# CITY OF PORTLAND BUILDING PERMIT

570 BRIGHTON AVE

PERMIT ID: 2013-00064

has permission to **Change of use on first floor from campaign headquarters to a Yoga studio on end unit by Fleetwood Street, minor interior alterations**

1ST FLOOR RESIDENTIAL

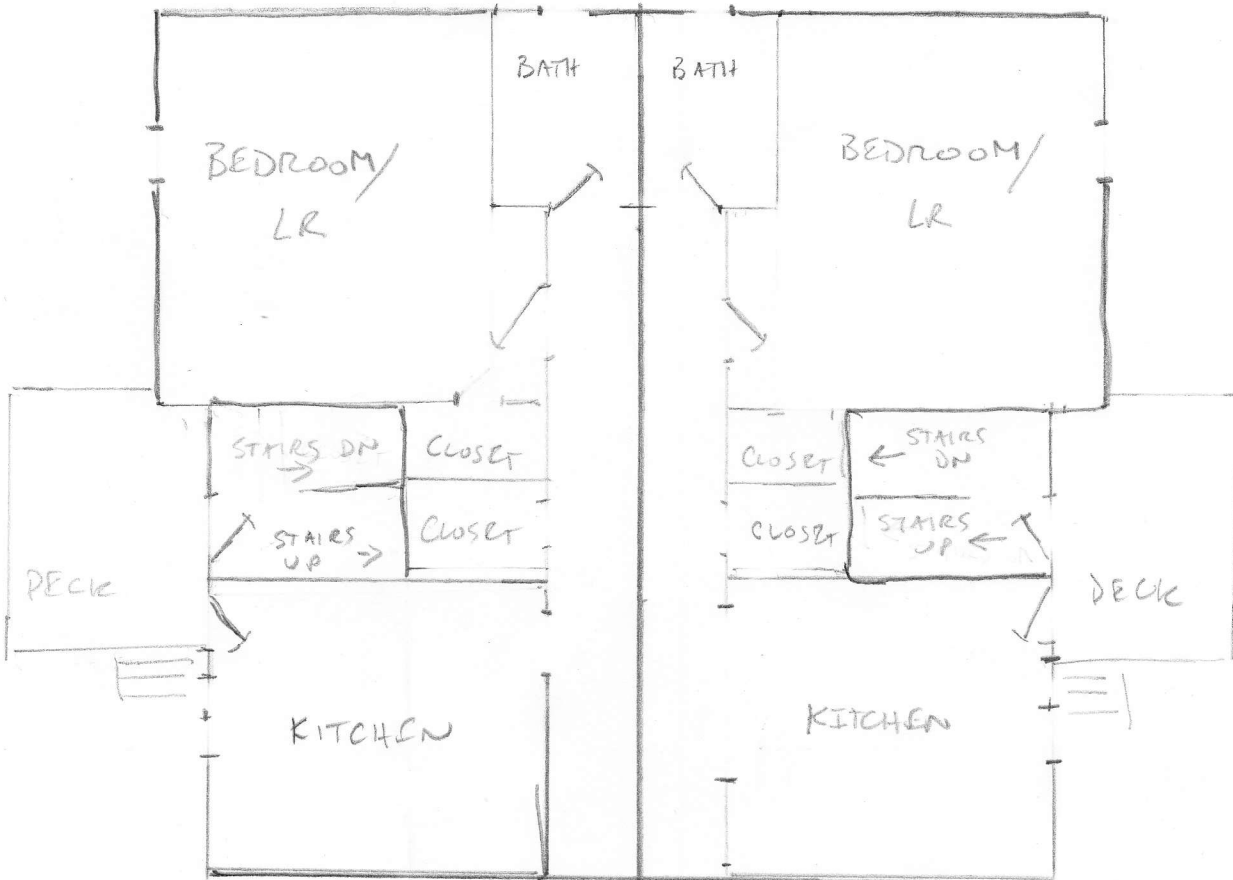
- 2) The existing ceiling may not provide a code compliant fire separation between mixed use occupancies. This will need to be addressed prior to the Certificate of Occupancy. Per the contractor, Tomasz M., the space above is vacant and he did not think it was a residential dwelling. Zoning has determined that the legal use of the 2nd floor is 4 dwelling units.
